Dakota Springs Engineering

Date: January 18, 2018

Subject: Springs at Waterview Preliminary Plan
SP-16-005

This memorandum has been prepared to address the comments you provided concerning the Springs at Waterview Final Plat in your letter dated November 27, 2017. Your comments are provided below with our response comment immediately following in *italics*.

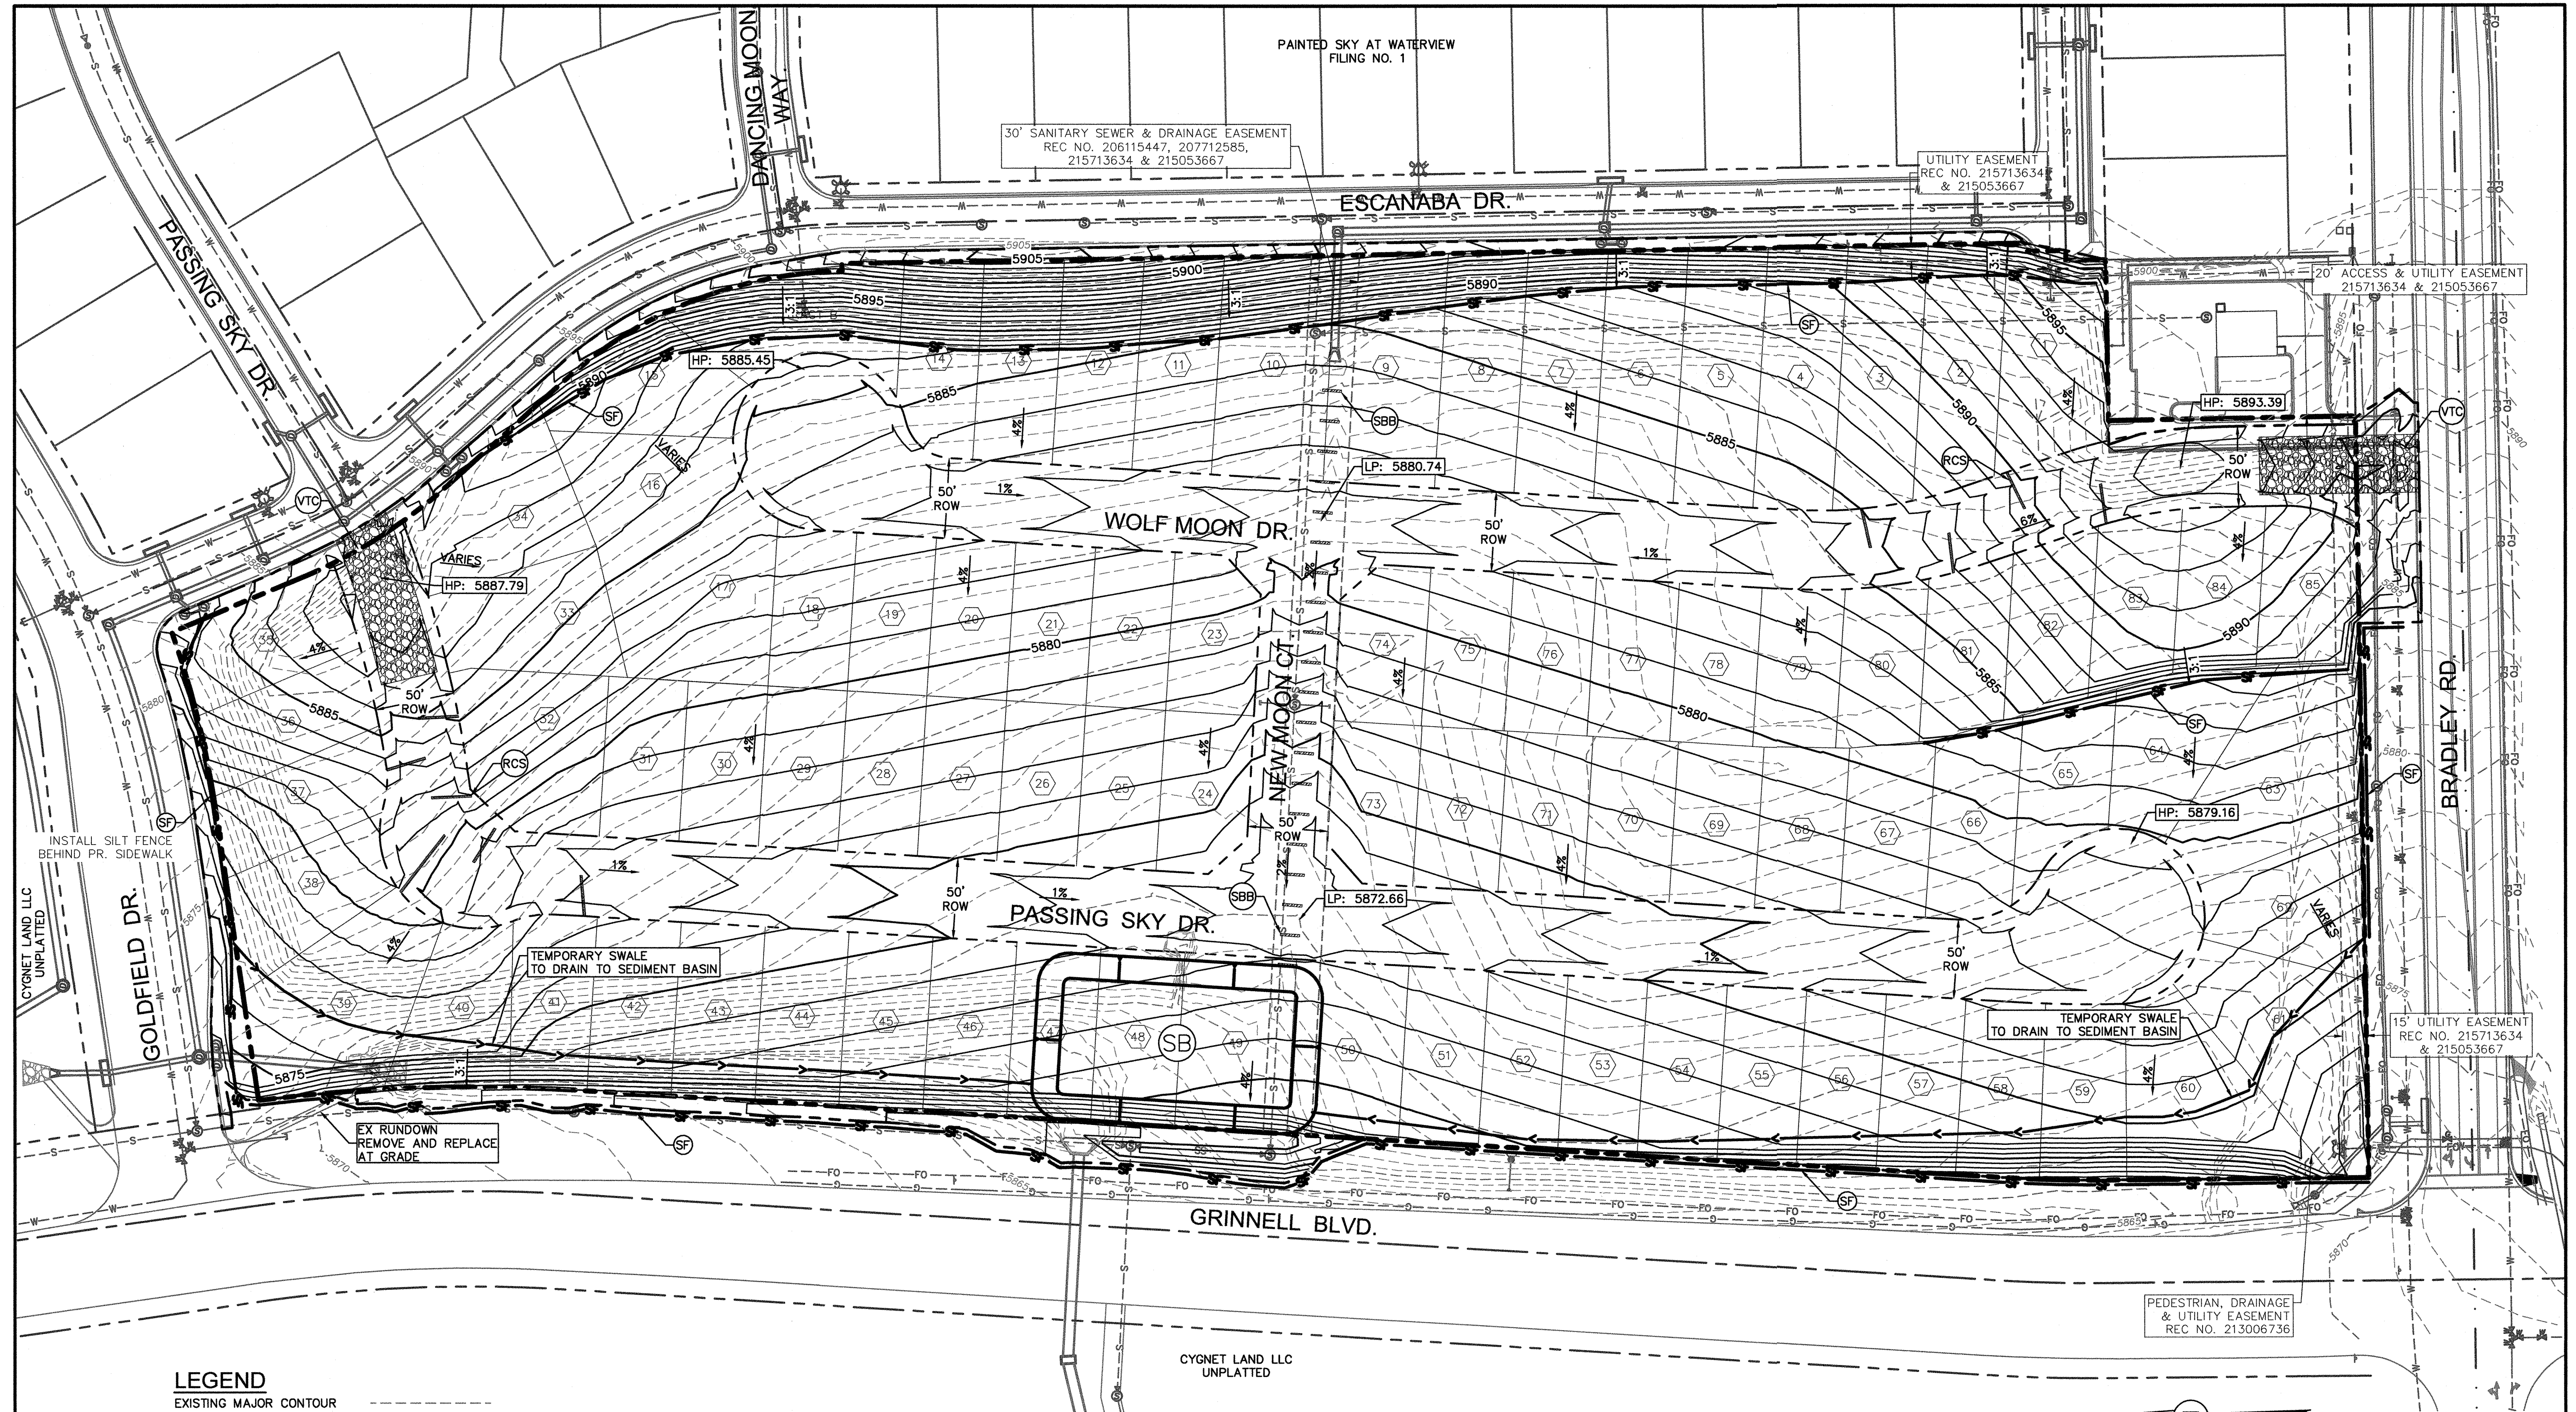
Change the street name from Grinnell Rd. to Grinnell Blvd. Item has not been addressed.

Addressed
